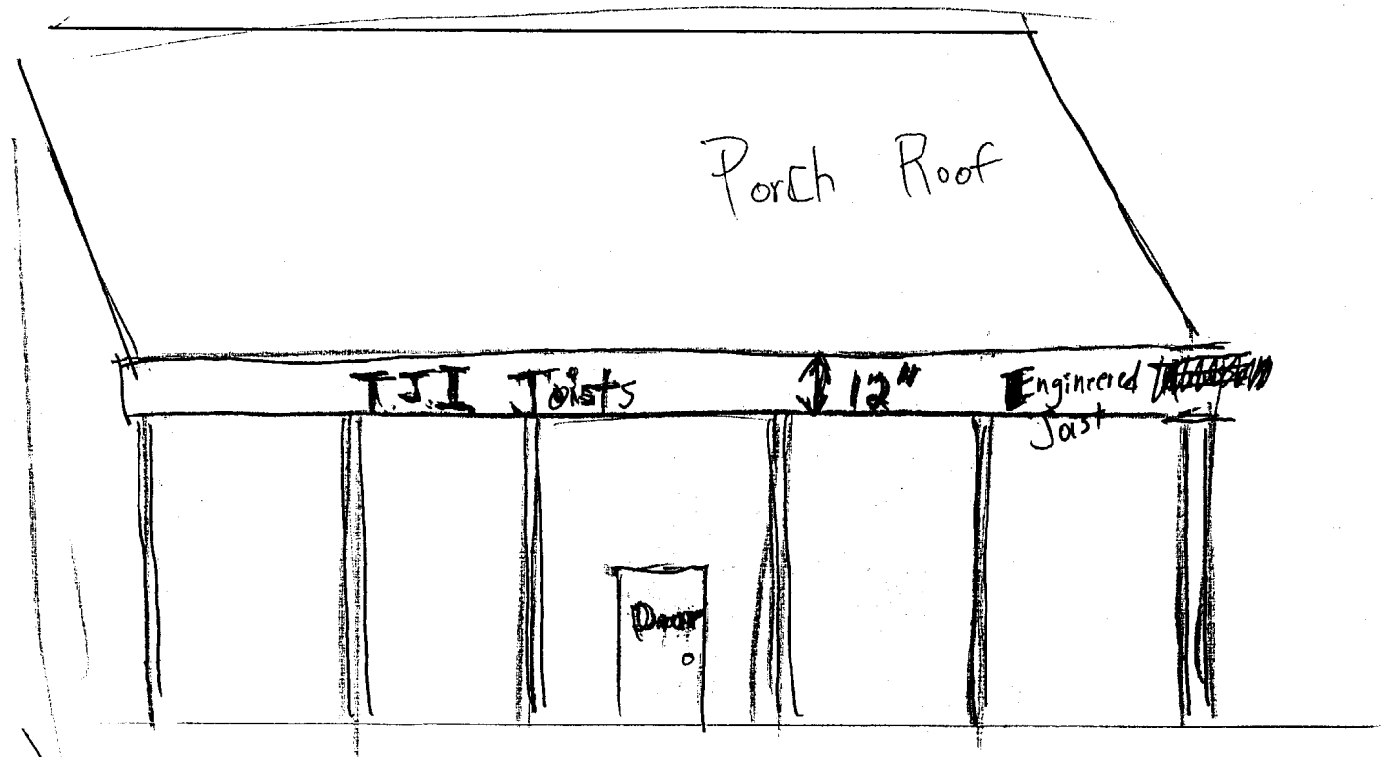
9/24/01 Footing/setback insp. 4' depth. measured
Setback to Right Front house corner 31'. Question of
Whether Front steps can encroach into setback. Deck
13'6" in width. JB
9/25 checked w/marge - ok 50 # into setback as long
as no more than 5' JB
